From: [REDACTED]
To: [Norfolk Boreas](#)
Subject: Norfolk Boreas Project EN10087
Date: 25 August 2020 21:24:39

These are my comments regarding the fifth round of questions.

SCENARIO 1
 Figure: 29.30b
 Viewpoint 8: Chapel Road, Necton

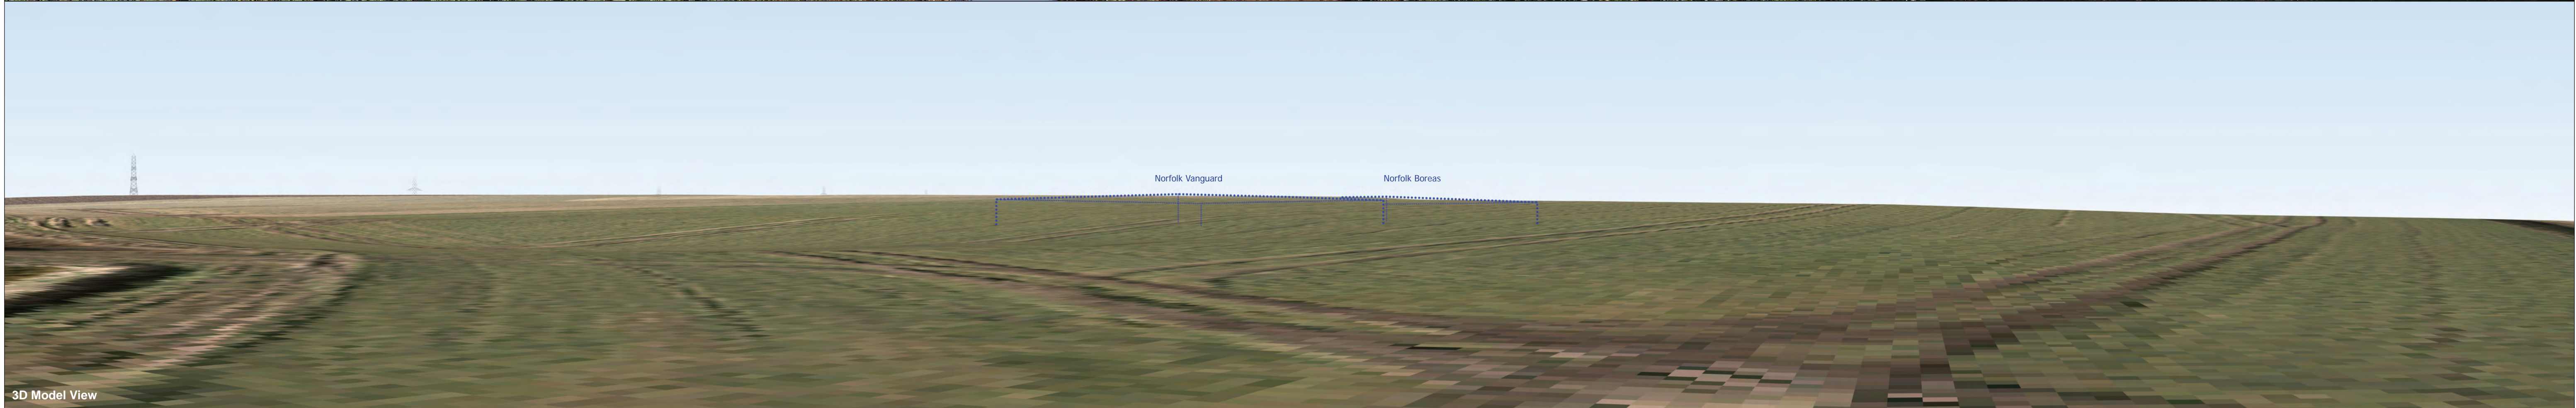
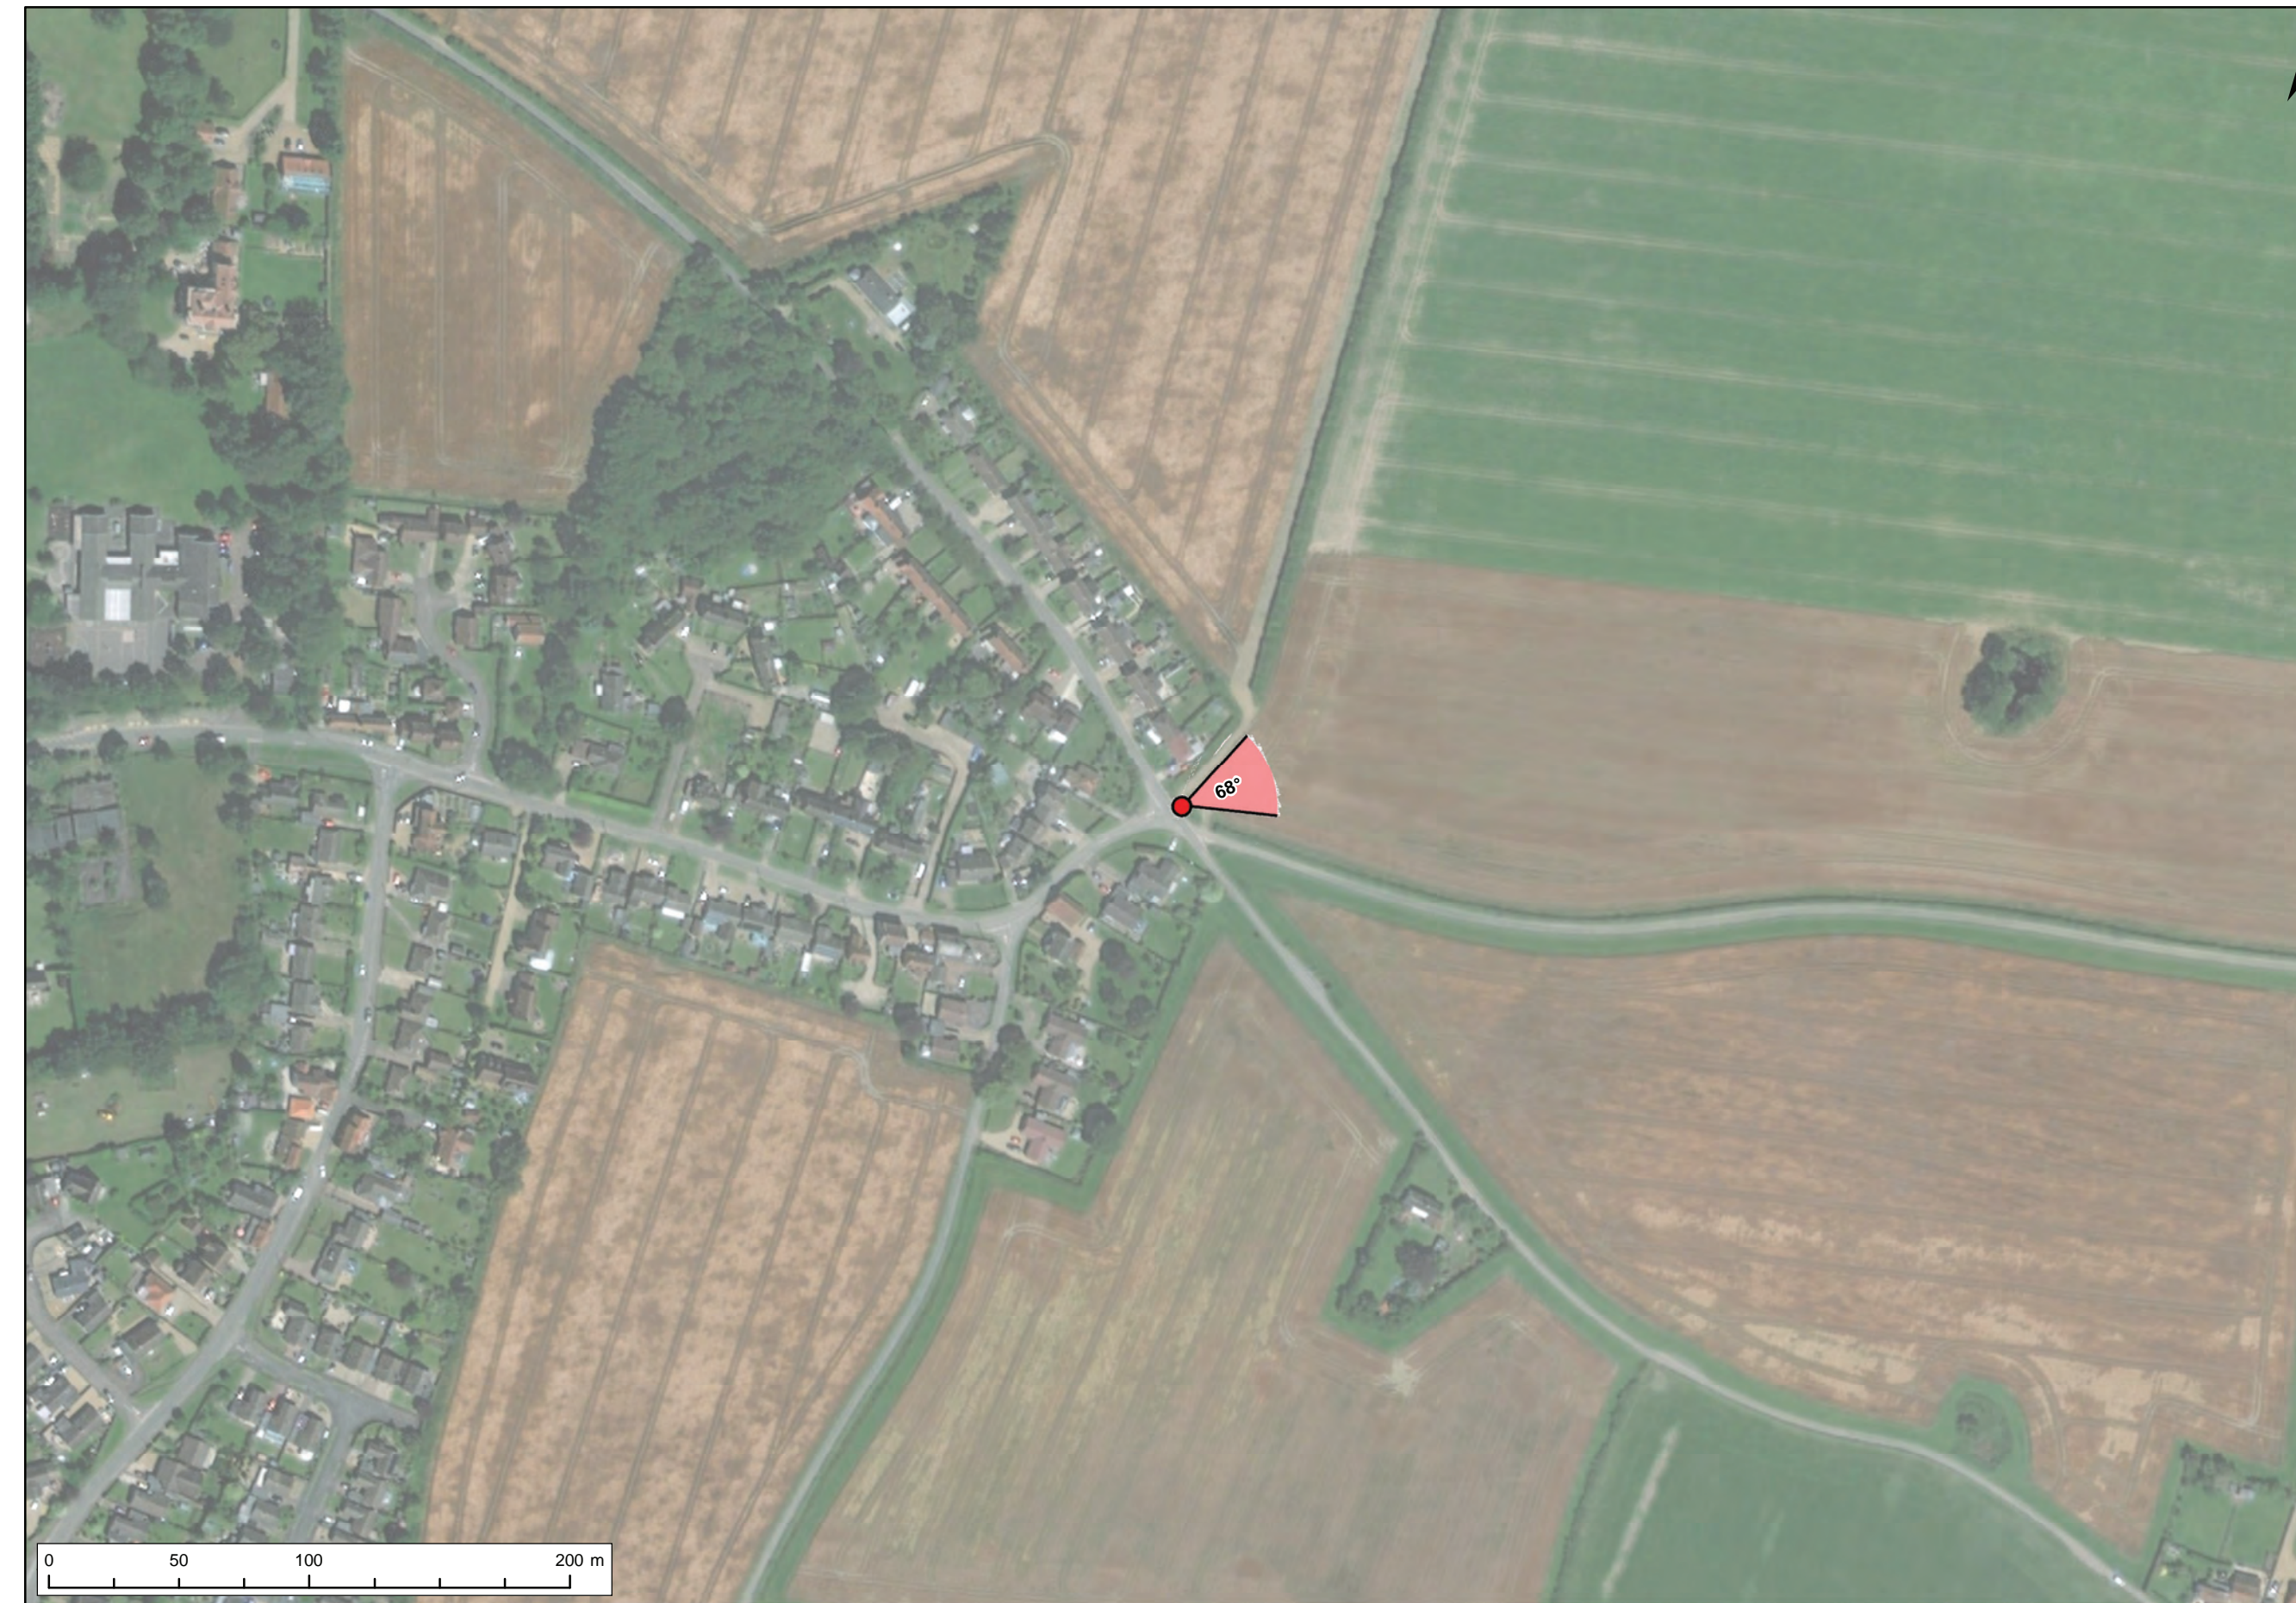
2. The SoS needed to be aware that the applicant's visualisations depicted the best case scenario, with applied blue dotted lines to depict the required worst case scenario. If the visualisations were presented as photographs of the views from the viewpoints, with only a blue dotted line box overlaid to demonstrate the extent of the impact from the presents of the substations, I doubt they would be considered suitable or adequate.

New visualisations are needed, showing the converter halls actually on the site, and in worst case scenario, for a revaluation.
